Subject: SUB22-006 Premium Homes Mercer Island Short Subdivision

Request for information #1

7216 93rd Ave SE

Andrew- Your comment letter from December 22, 2022 has been pasted below. Our responses have been added in red text following each comment. Please note additional responses may be provided by other consultants.

# TREE RETENTION PLAN

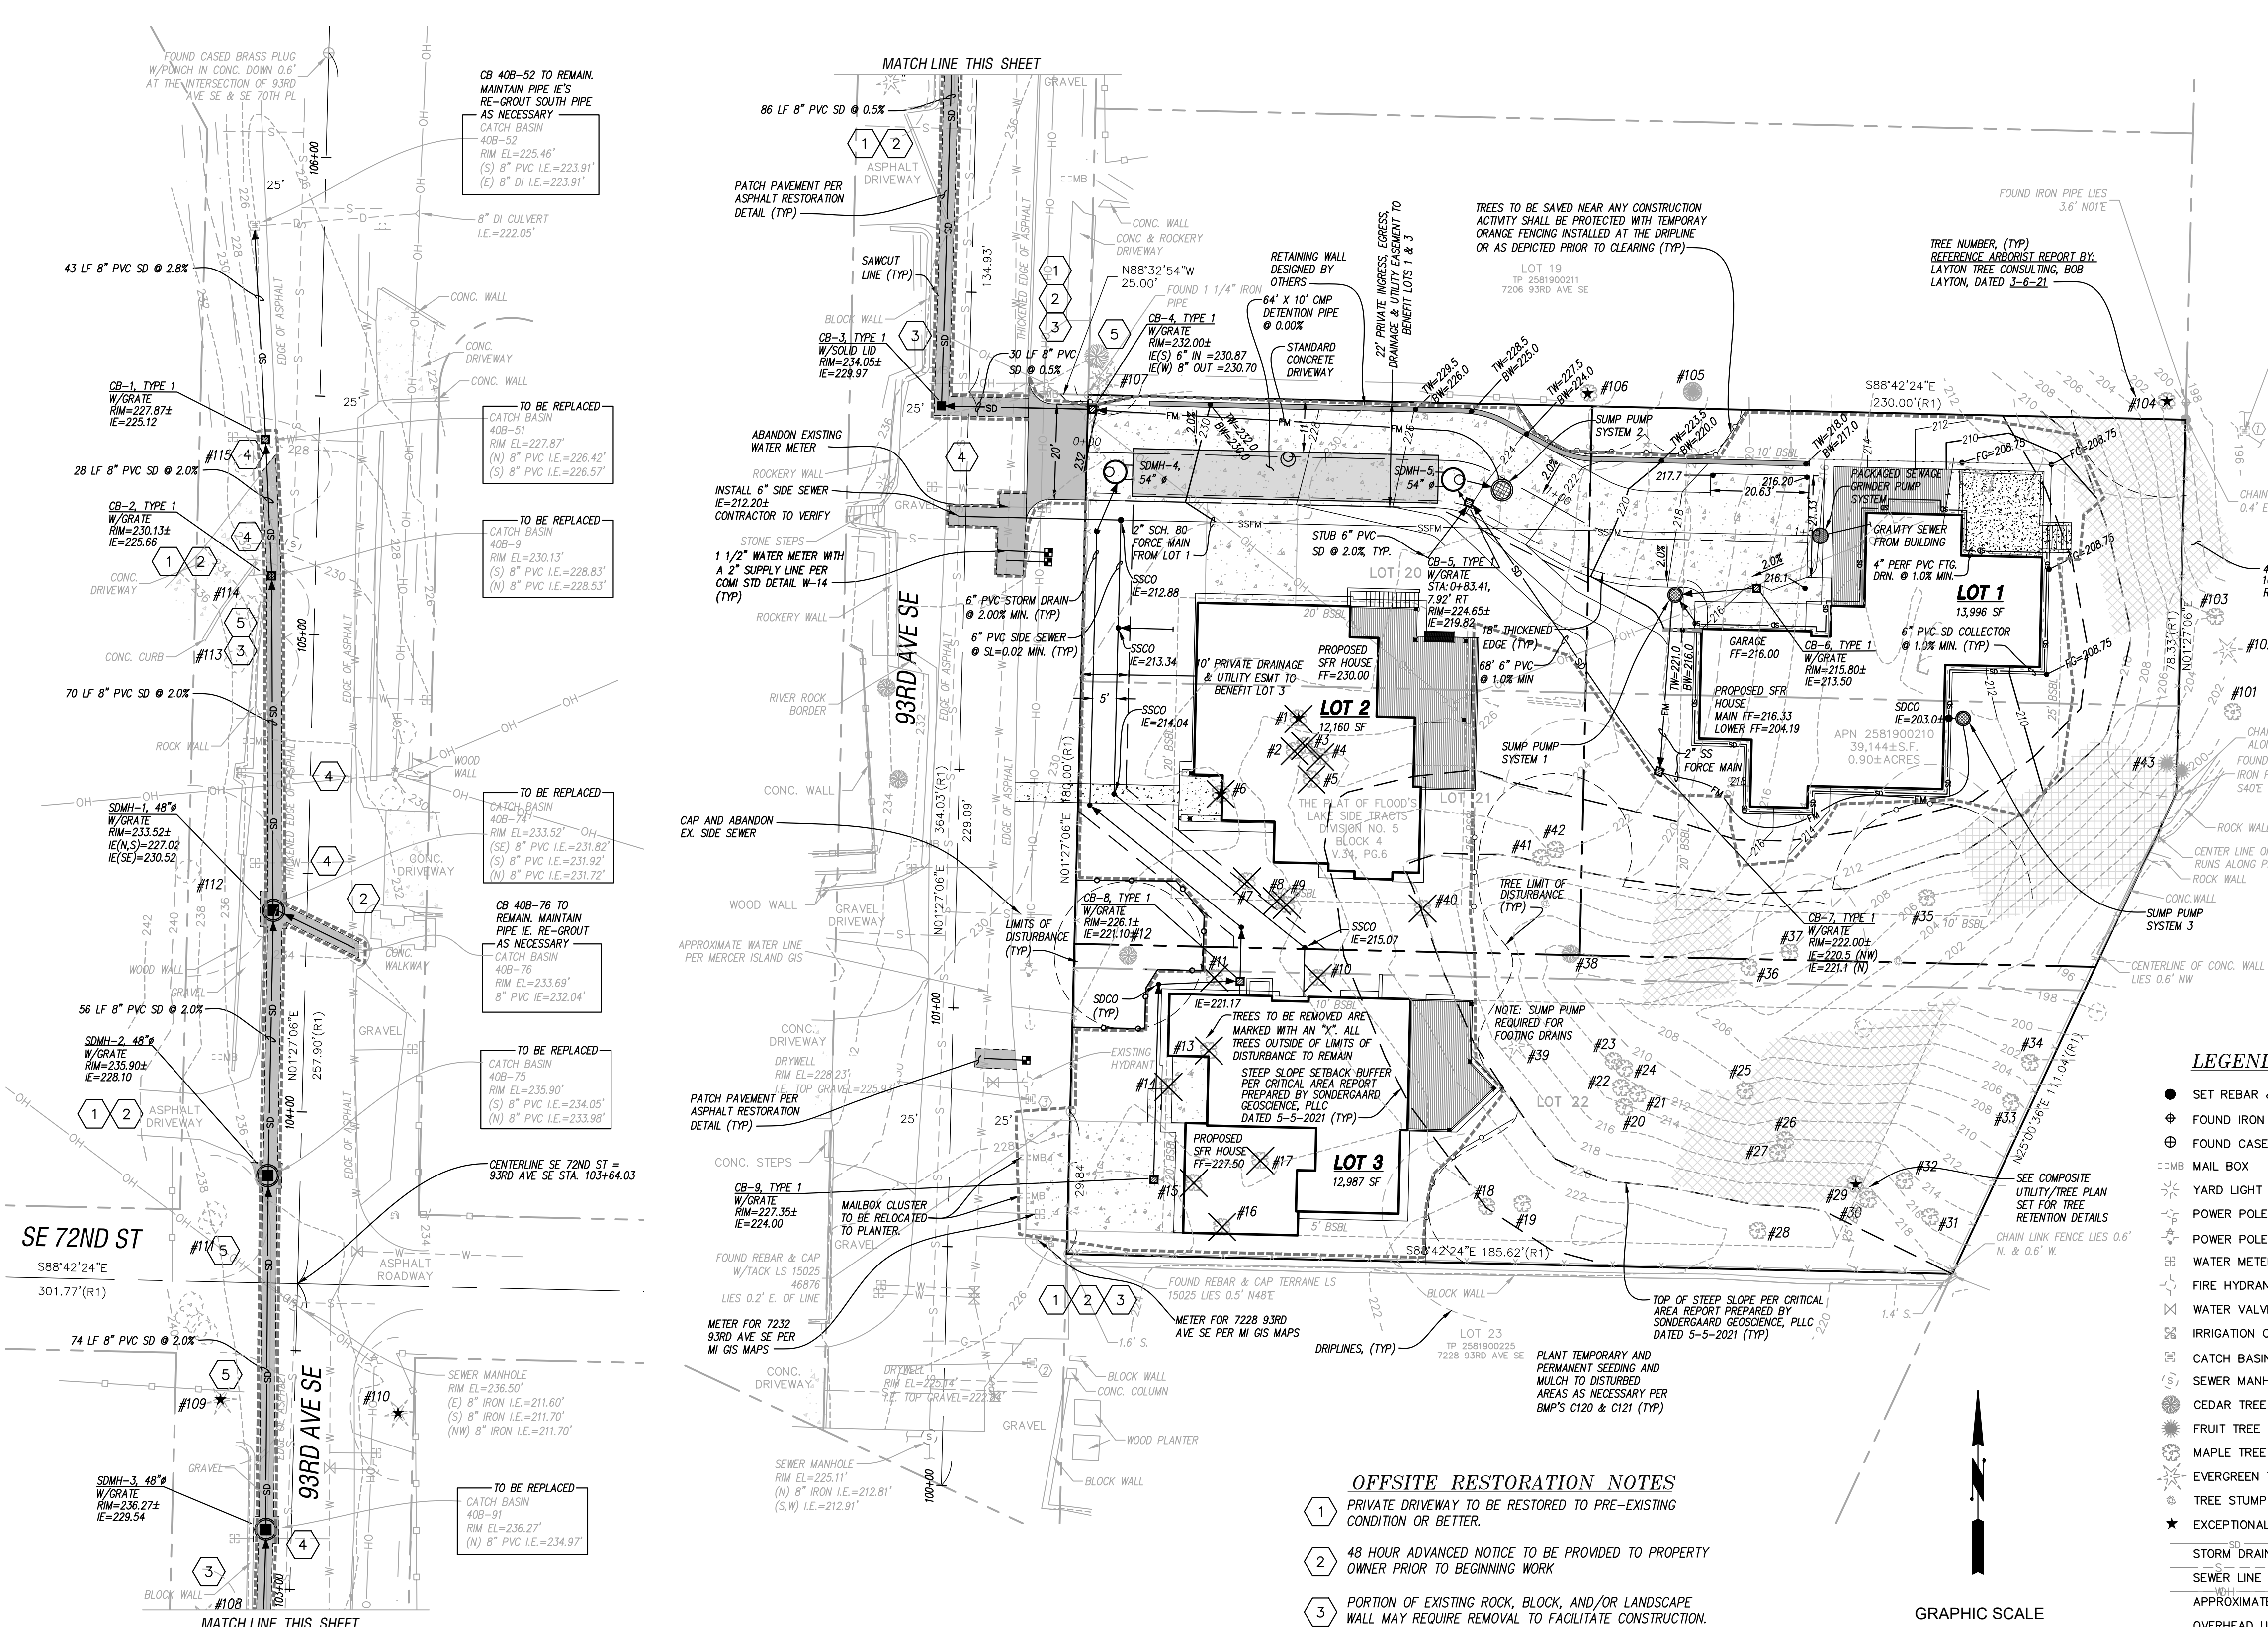
1. (For architect) Tree 12 appears to be an exceptional grove tree over 24 inches in diameter and would need to be retained and protected at its dripline as provided by the arborise. This would include moving the building pad and installing any utilities in the

proposed easement so they do not damage the tree. This would also include tunnel/bore trenchless technology or air excavation under Certified Arborist direction. Alternatively, the tree could be removed if you can justify the removal under MICC 19.10.060(A)(3). **Tree 12 will now be retained. Construction adjacent the tree at the corner of the house will consist of a pile shoring wall to reduce the excavation in this location. The project arborist has reviewed impacts from this wall and the required 5' access around the building. He has provided a letter with his recommendations and opinion that the tree is expected to remain in its current condition throughout and beyond construction.**

3. (For architect/arborist) Tree 18 is an exceptional grove tree over 24 inches in diameter. The arborist lists the limits of allowable disturbance as 16 feet from the trunk of Tree 18. The limits of clearing and tree protection are shown as 12 feet from this tree on the plans. Please reassess the building pad of Lot 3 to provide the tree protection recommended by the arborist. Please also provide a setback of at least 5 feet between the building pad and the tree fence so there is room for construction access. Alternatively, provide an area excavation root analysis to confirm the limits of allowable disturbance by your project arborist. **Tree 18 will be retained. Air excavation and root analysis by the project arborist has been done and is included with this submittal. Per that analysis and recommendations, the tree fence and limit of excavation is shown 6'-0" away from the building and 11'-4" away from the face of tree 18. Ecoblock shoring will be provided in this location to reduce impacts to the tree.**
